Online Comment

Application H16-0319-26
Location 1 New Road Spalding Lincolnshire PE11 1BS
Proposal 2 Fascia Signs & 3 Barbers Poles - Retrospective

Name Gregory Watkinson, Principal Conservation Officer
Address Council Offices Priory Road Spalding PE11 2XE

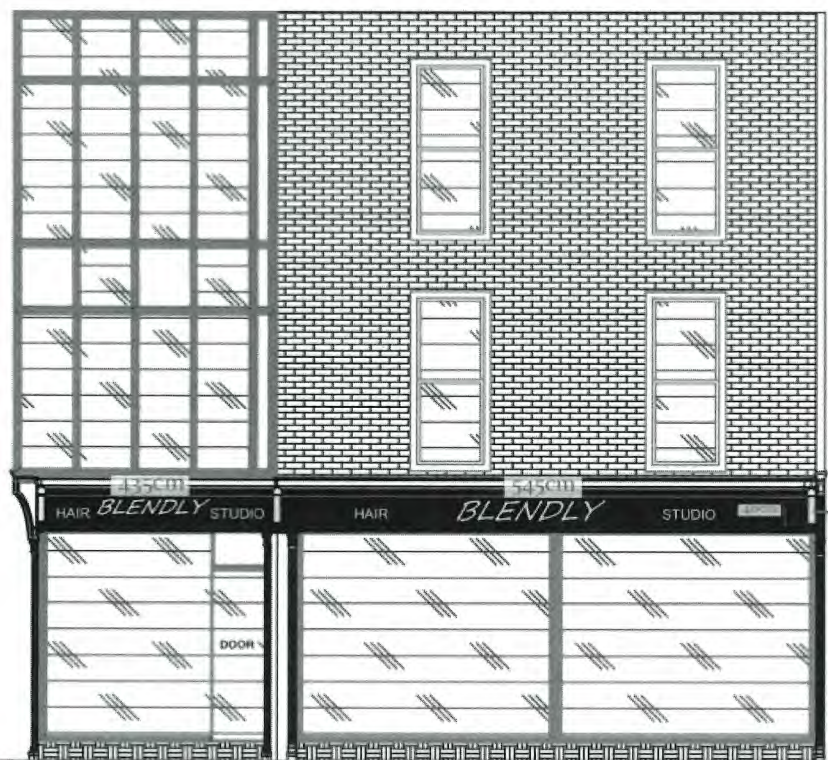
The design of the signage itself is relatively attractive and a definite improvement over the former signage on the property. However, the raised lettering utilises Internal or Halo illumination, which also upon visual inspection of the site, is lit in bright primary colours (at the time of the visit, the backlighting was bright green). In general, internal or halo illumination are not considered to be appropriate forms of shopfront lighting in a conservation area setting, particularly not for properties which retain a relatively traditional shopfront. This is exacerbated as an effect by the RGB colour capability of the proposed lighting which exaggerate the appearance of the proposal as being non-traditional and alien in appearance to the relatively traditional nature of sign lighting elsewhere in the conservation area.

Without an exceptional justification, it is my stance that the proposed lighting does cause a form of harm to the setting of the conservation area and as such, fails the test set forth by Policy 29, Section B(5) of the SELLP.
